Reference Number: H17-1097-23

Proposal: Proposed plant based protein extraction facility and anaerobic digester plant

Location: Land East of Surfleet Bank and West of Woad Farm

My Ref: JF
Your Ref: H17-1097-23

Project PROPOSED FACTORY AND AD PLANT		
Address LAND ADJACENT A16 SURFLEET LINCOLNSHIRE		
Client NAYLOR FARMS		
Drawing PROPOSED SITE PLAN		
Date DEC 2023	Scale 1:1000 @ A1 - 1:2000 @ A3	
Project No. 3952	Drawing No. P01	Revision A

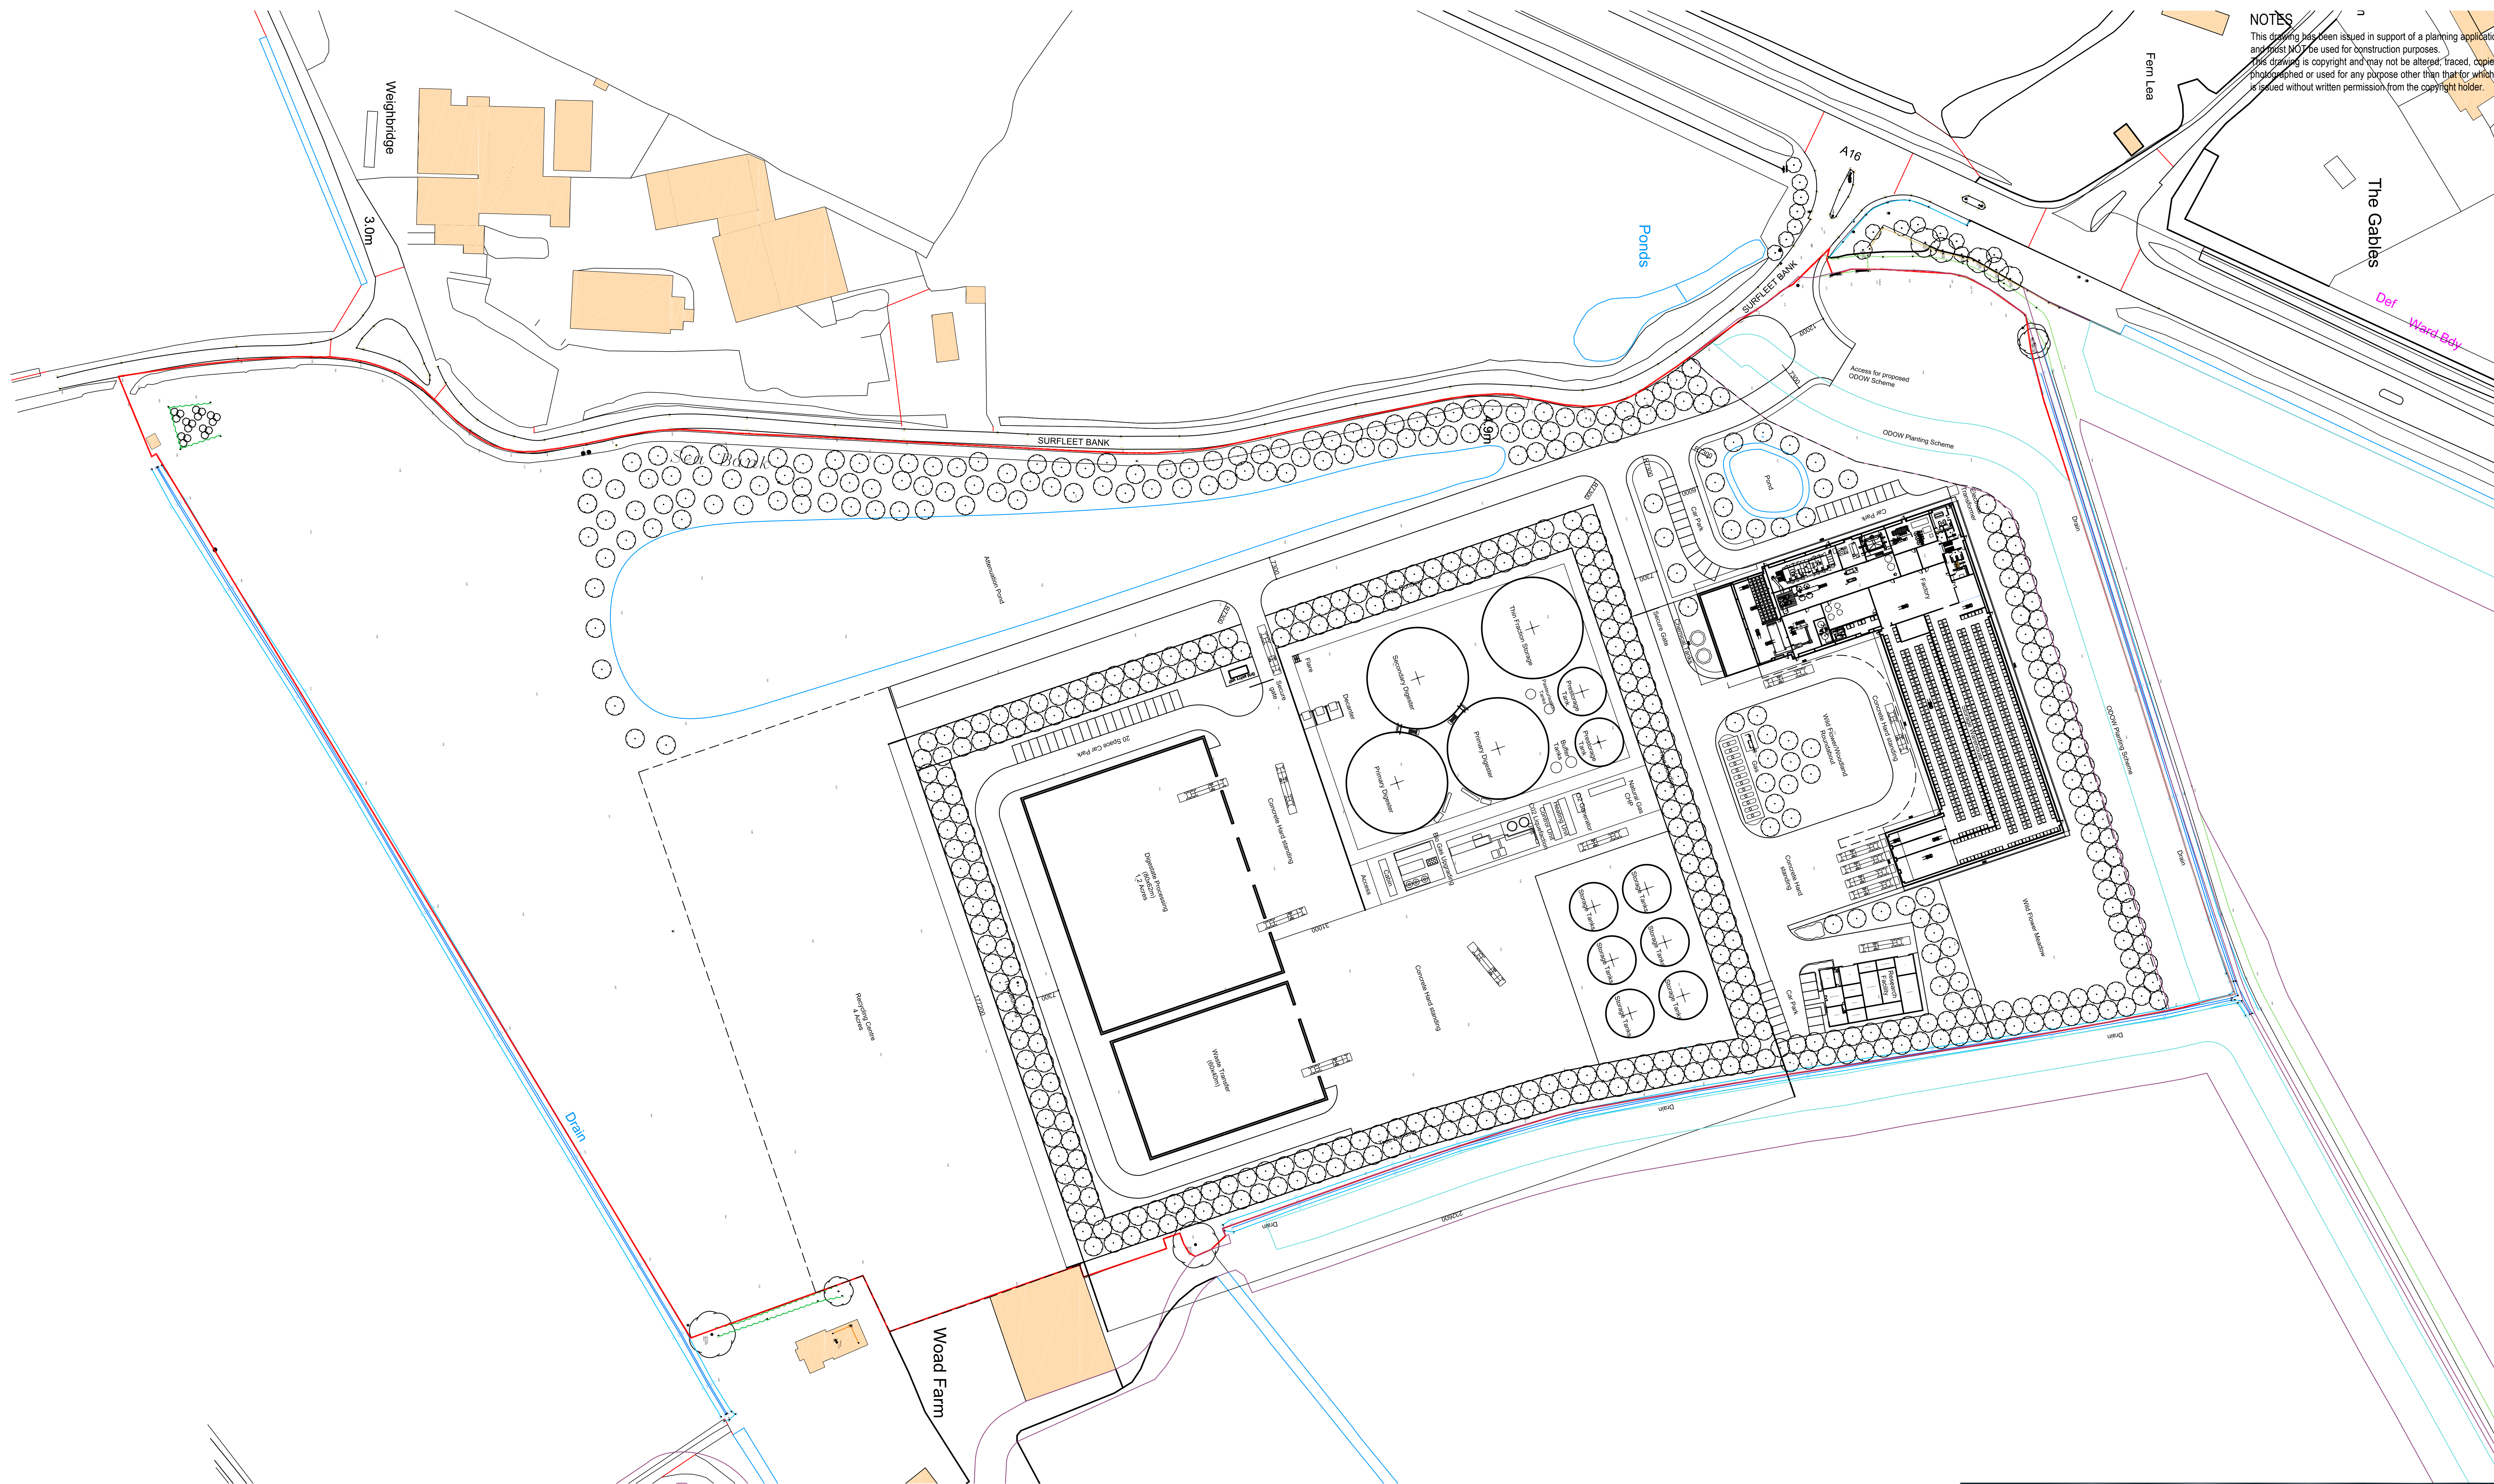
It is important that there is an adequate provision of water supply for firefighting purposes. It is acknowledged that two attenuation ponds are to be included within the development. These ponds may be sufficient sources of water for firefighting purposes subject to meeting the following criteria as set out in Approved Document B Part B5:

- **A spring, river, canal or pond that is capable of fulfilling both of the following conditions.**
 - i. **Providing or storing a minimum of 45,000 litres of water at all times.**
 - ii. **Providing access, space and a hardstanding for a pumping appliance.**

If the ponds do not meet this requirement then Lincolnshire Fire and Rescue will require the installation of one fire hydrant conforming to BS750-2012 within 90m of the premises entrance in respect of this planning application to be provided at the developer's expense. Fire hydrant acceptance testing will be carried out by a Hydrant Inspector on completion and a standard hydrant marker "H" plate will be fitted nearby. Following adoption the Fire

Alternatively, a charged static water tank with a minimum capacity of 45,000 litres can be provided as a water supply for firefighting purposes.

Lincolnshire Fire and Rescue also requires a minimum carrying capacity for hard standing for pumping appliances of 18 tonnes, not 12.5 tonnes as detailed in the Building Regulations 2010 part B5. This weight limit would also apply to any private/shared access roads in order to achieve the above item.
